**Subject:** SP-24-00014 MLH - Notice of Application

**SUBJECT: WDFW COMMENTS ON SP-24-00014 MLH SHORT PLAT**

**TO:** All Staff  
**FROM:** Public Works Plan Review Team  
**DATE:** December 2, 2024  
**SUBJECT:** SP-24-00014 MLH

**Critical Areas Map**

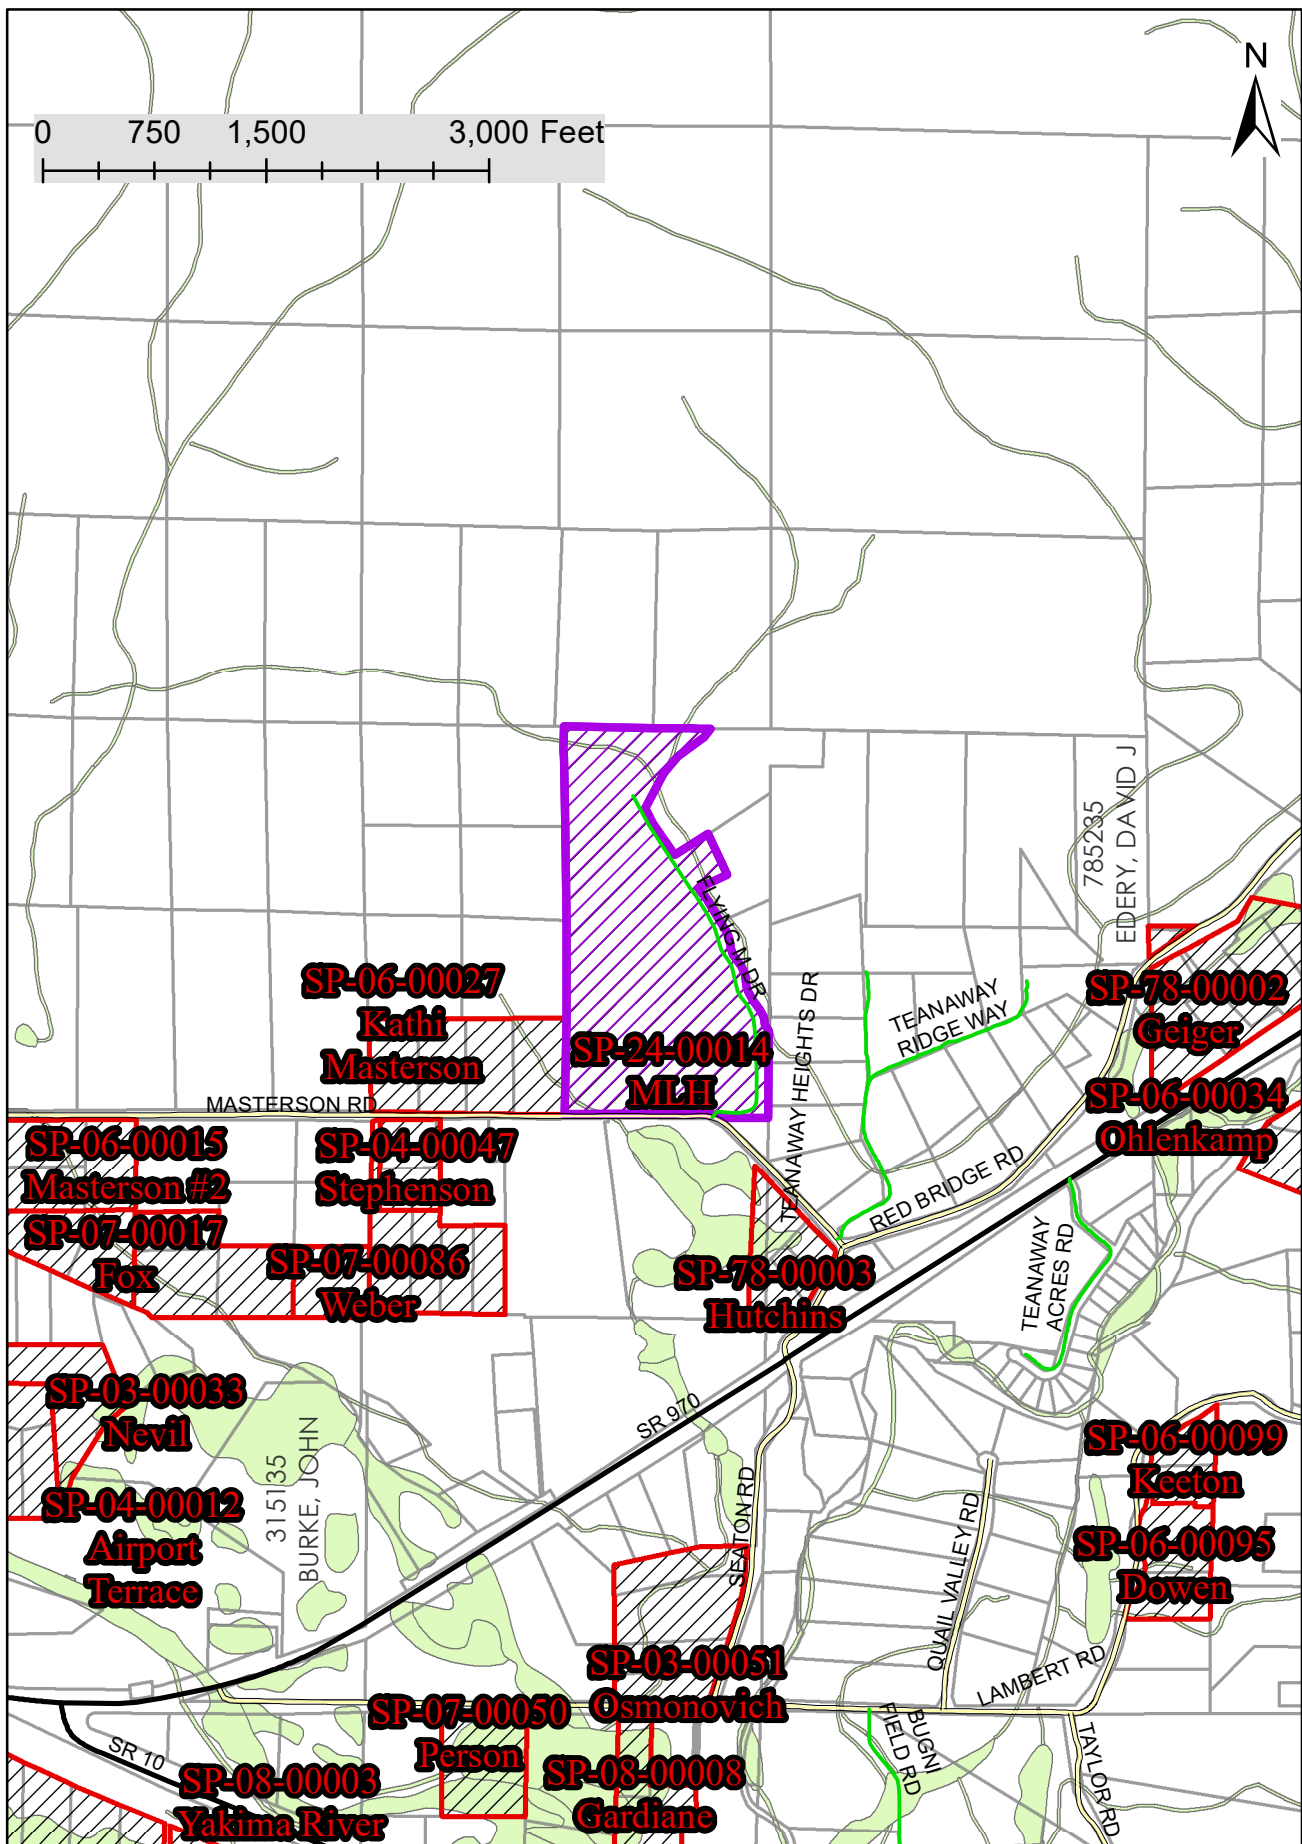
We understand that this proposal is a short plat, and no development actions are currently proposed. While no critical areas report is provided with the application materials, there are critical areas present on the subject parcels, including Fish and Wildlife Habitat Conservation Areas (FWHCA). Prior to new parcels being created as part of this project, the applicants should clearly demonstrate that they are not creating lots that will require variances and/or reasonable use exceptions from the critical areas requirements or other relevant sections of code when development is proposed.

There is an unnamed tributary that has previously been captured by the old Masterson Ditch. This watercourse appears to continue through the parcel and irrigated land in a straightened ditch like feature, before crossing Masterson Road and eventually enters the Teanaway River. This watercourse should be acknowledged and shown in the plans to ensure appropriate riparian management zones are applied to future land uses. This project area is also in a known elk winter range area.

- Prior to approval of this application, complete a critical areas report that identifies all critical areas present within the project area and the required setbacks. Completing this report and assessment will result in the identification of areas where development would be allowed without the need for variances or reasonable use exceptions.

- If a critical areas report is not completed prior to approval, we recommend identifying the water course and the development envelope outside of critical areas and their setbacks to ensure future development will protect the unnamed stream.

MLH SHORT PLAT
PART OF SECTIONS 28 & 33,
T. 20 N., R. 16 E., W.M.
KITTITAS COUNTY, WASHINGTON

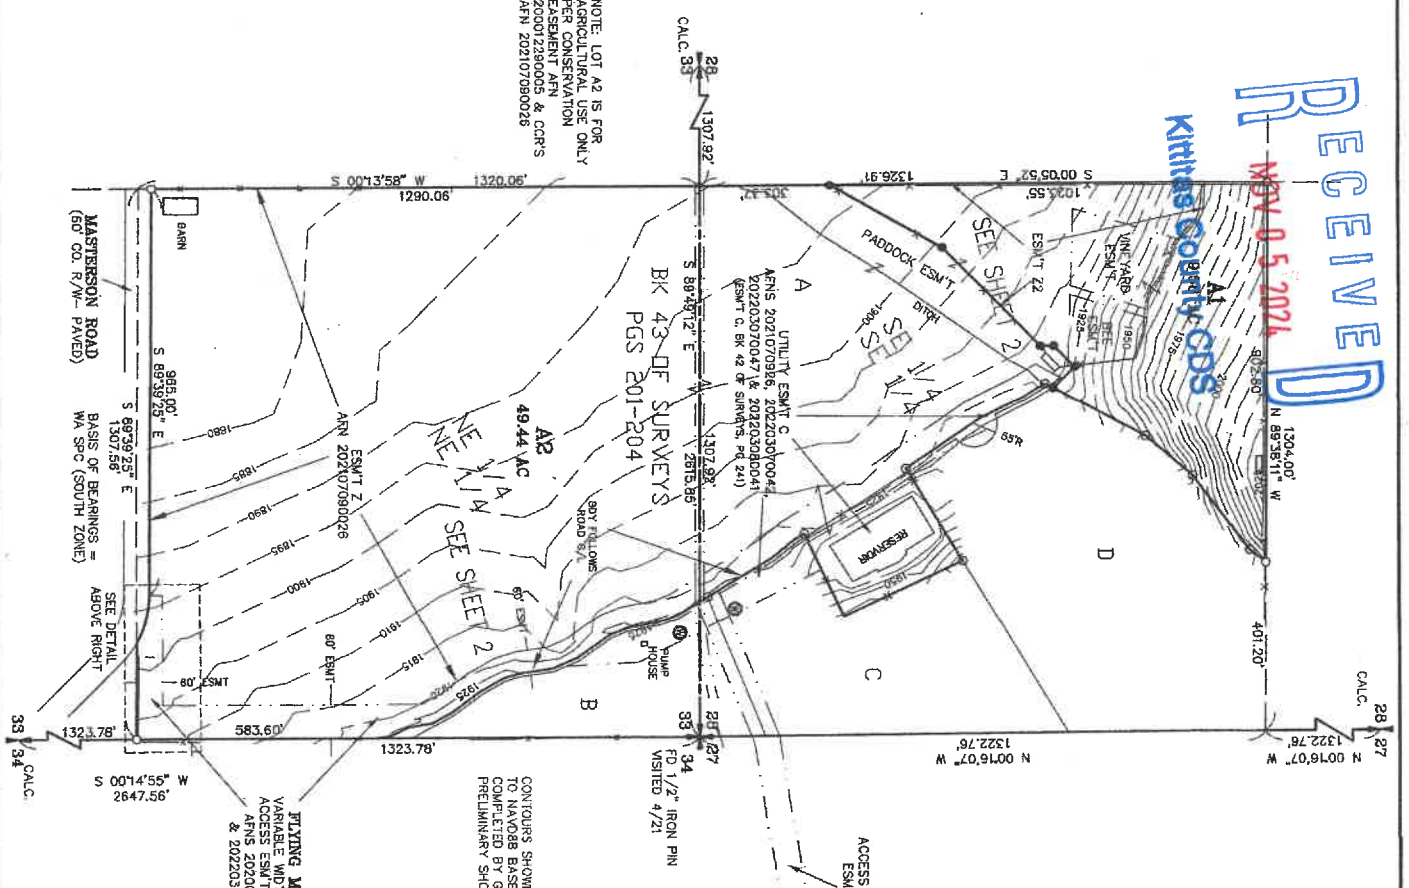
1. Lot A1 will need to submit an adequate water supply determination as well as a well log for drinking water on the lot.
2. Lot A1 will also need to submit a soil log.
